## **WEST MIDLANDS INTERCHANGE**

### **WRITTEN REPRESENTATION**

drawing title
PHOTO VIEWPOINT AND PHOTOMONTAGE LOCATIONS - INSET PLAN

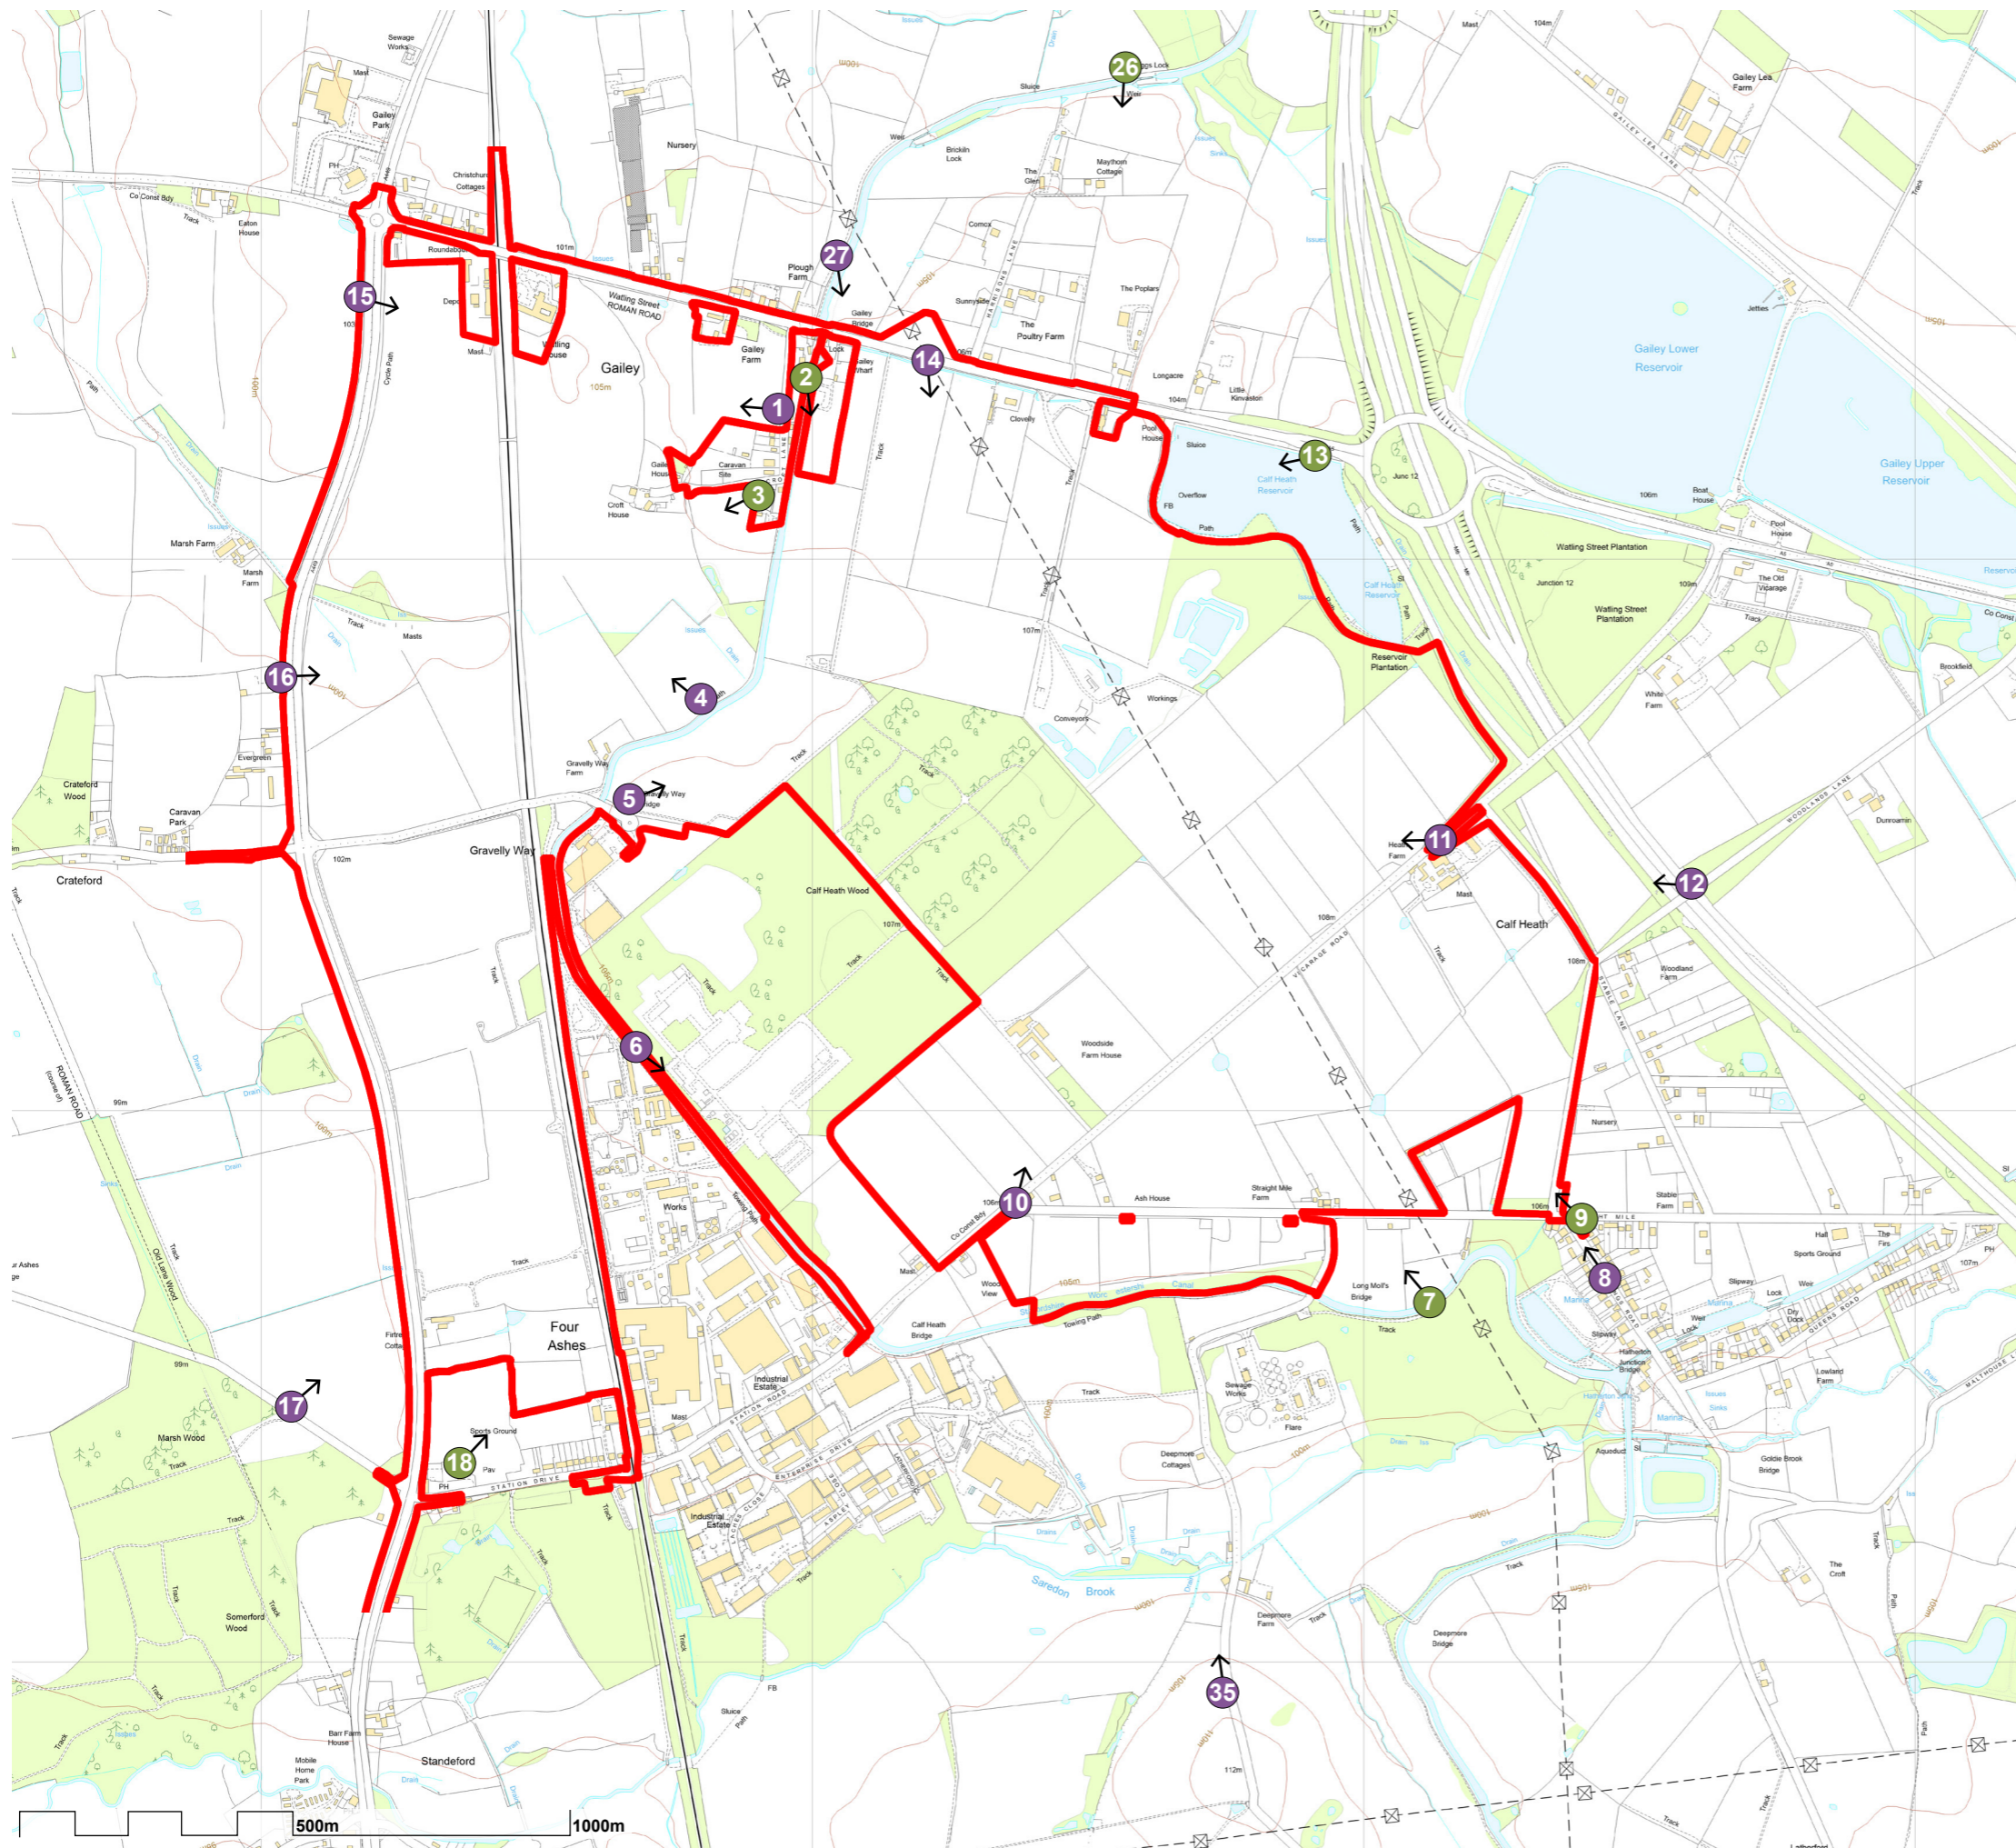
- 2.9. Phasing is particularly critical to limiting visual effects. Assessment is hampered by the fact that the visual receptors bear little relation to the Photo viewpoints, and in the assessment of impacts Construction Impacts is not included in the Visual Effects Table. Further, the effects of lighting are not included in the Table and Description Notes. The LVIA acknowledges that for some receptors there will be the potential for some construction activity and warehouse units to be more visible due to the later sequencing of the proposed mounding and planting, and it is understood that the earthworks strategy limits mounding being brought forward. Key receptors that will be subject to greater detrimental effects due to sequencing are highlighted in the ES (SS12.237 to ss12.256). Although some effects may be partially filtered by intervening vegetation (which will subsequently be removed as phasing progresses). From some locations there may be periods of open views of partially complete and/or complete development without the benefit of screen bunds or much intervening vegetation; and it will take time for new planting to establish sufficiently to deliver mitigation. The Council considers that for
